EPC STORMWATER REVIEW COMMENTS
IN ORANGE BOXES WITH BLACK TEXT

NOR'WOOD BIBLE CHURCH

LOT 38, SADDLEHORN RANCH FILING 3

Grading & Erosion Control Plans

SHEET:  
**G2.0**

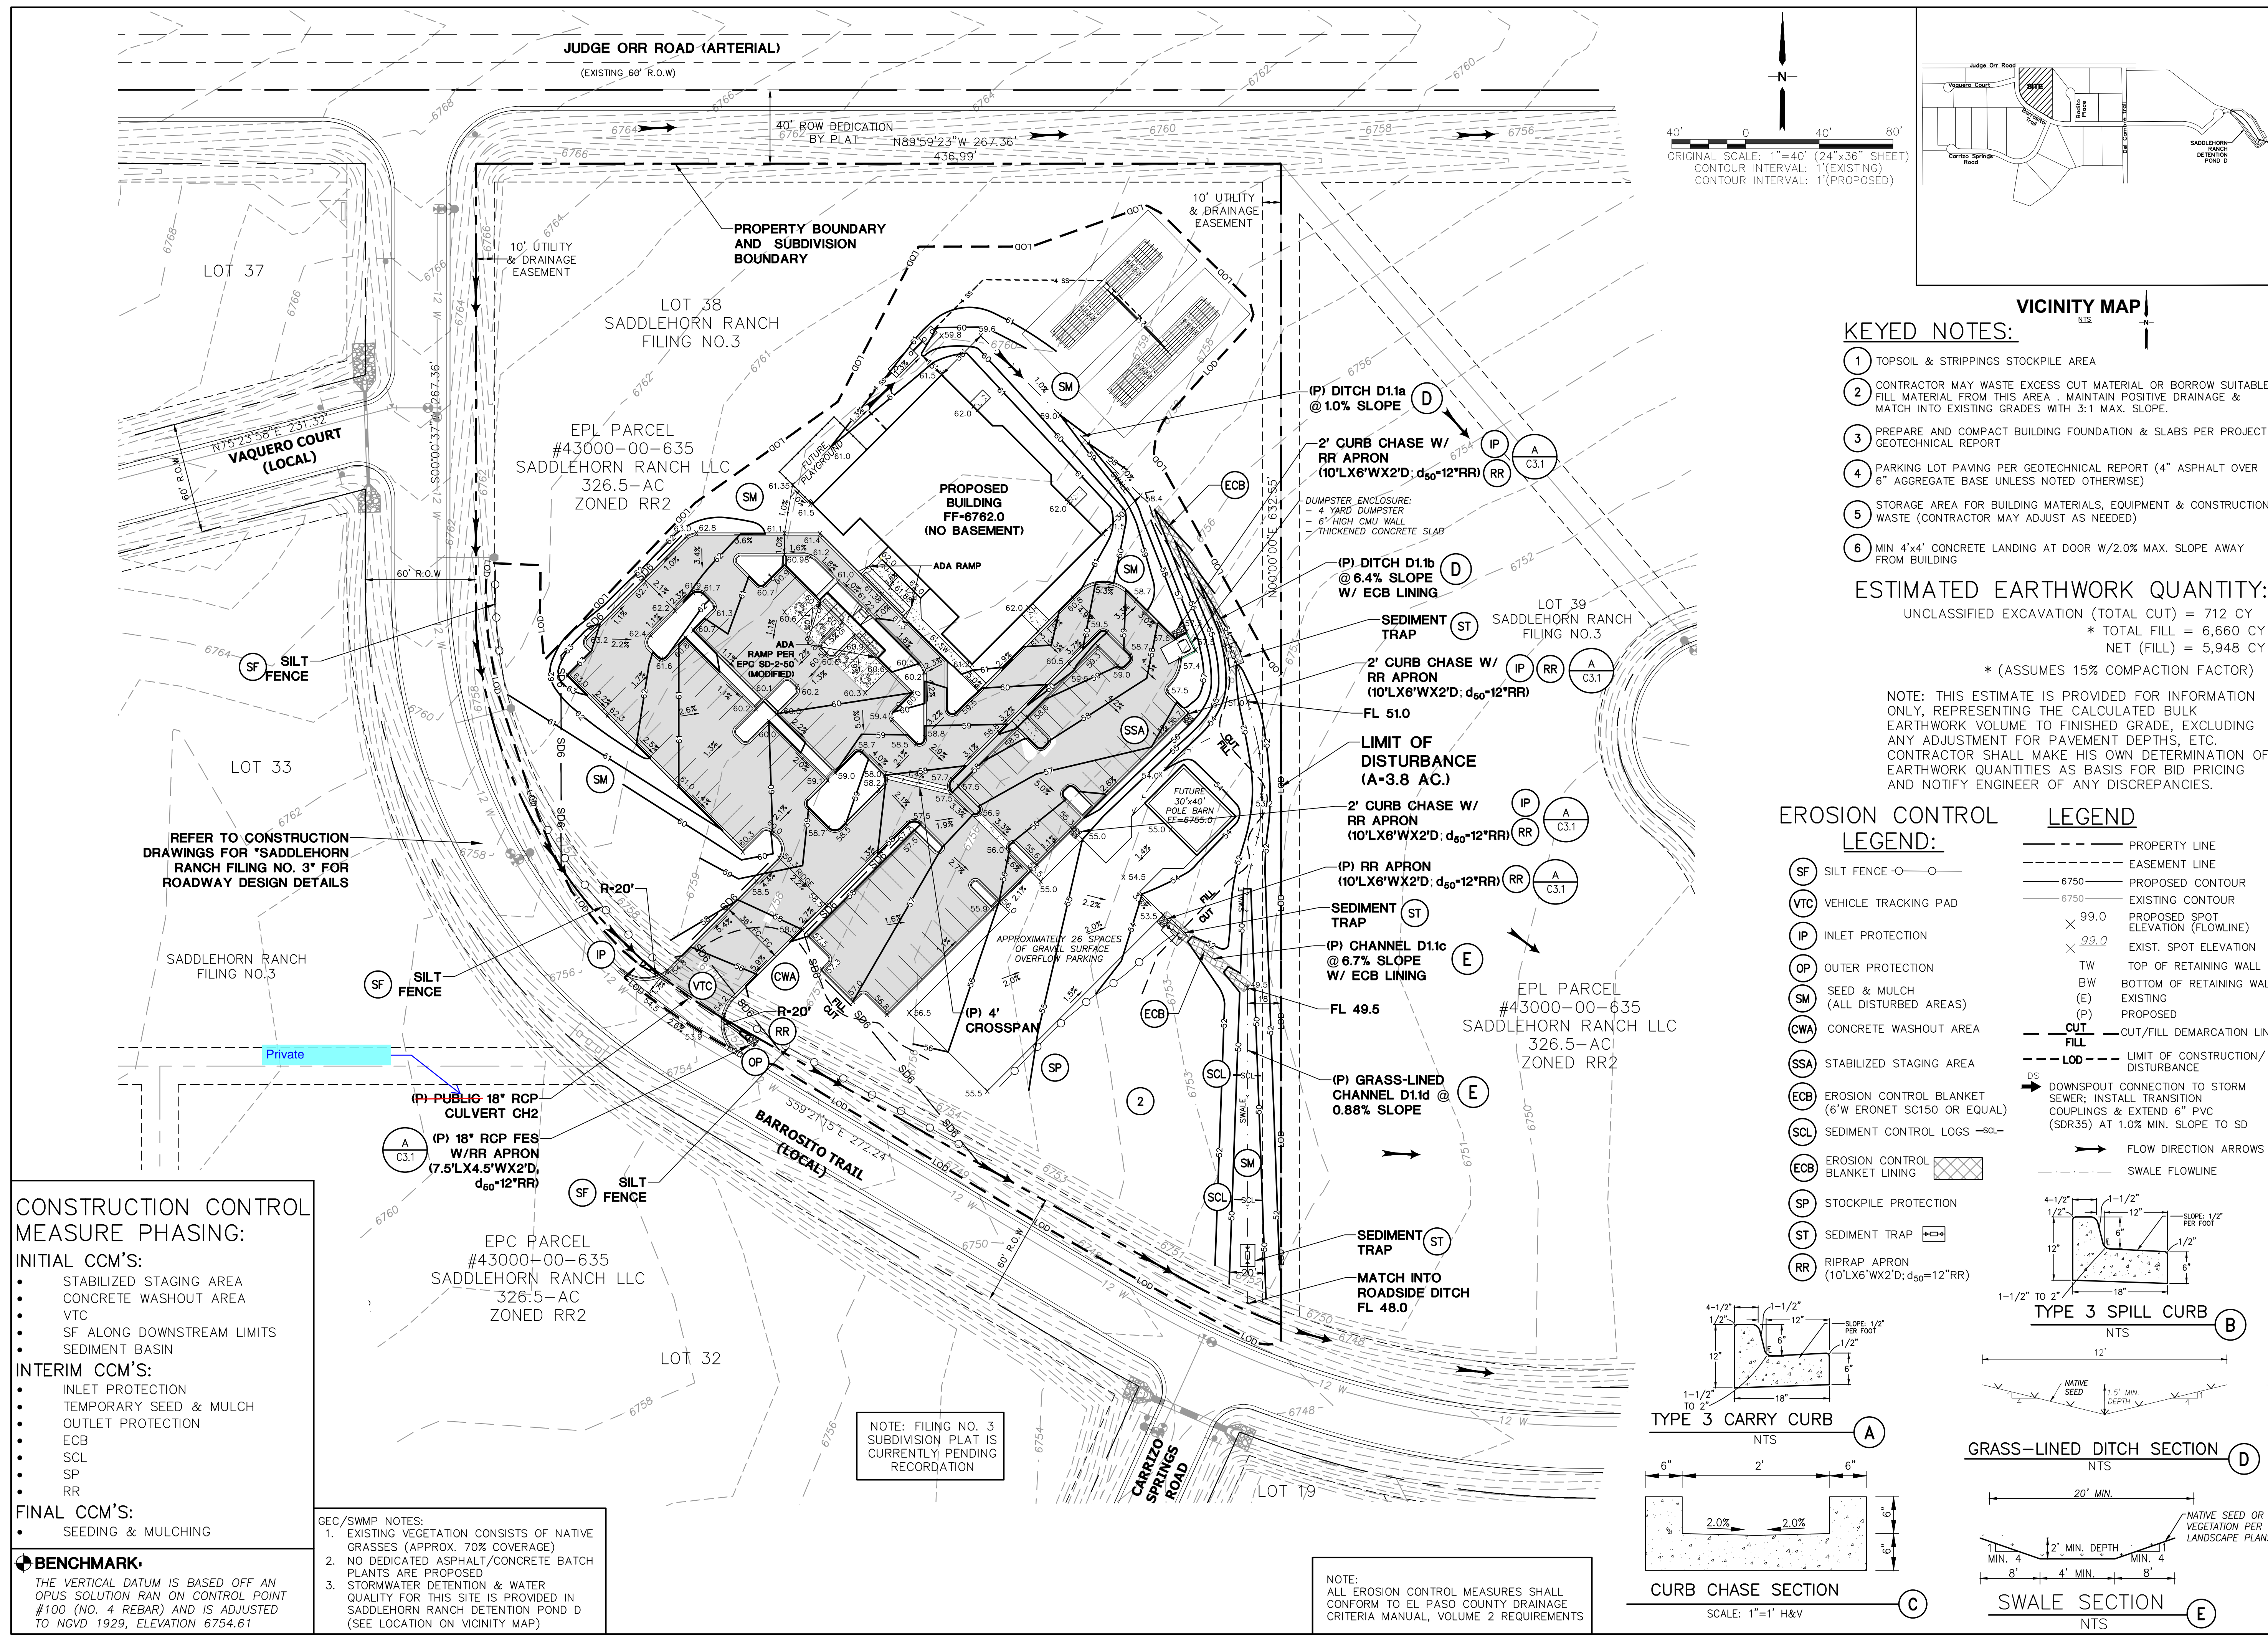
Add Construction Note 16. "El Paso County does not own and is not responsible for the underdrains or groundwater discharge systems shown on these plans and assumes no liability for water rights administration by approving these plans. Maintenance and water rights are the responsibility of the developer and ____ [xx metropolitan district, or yy property owner's association] ____."

Hay bales are not shown on the drawings

GEC Checklist Item i - show existing vegetation of add note stating the type and percent of ground cover that has vegetation.
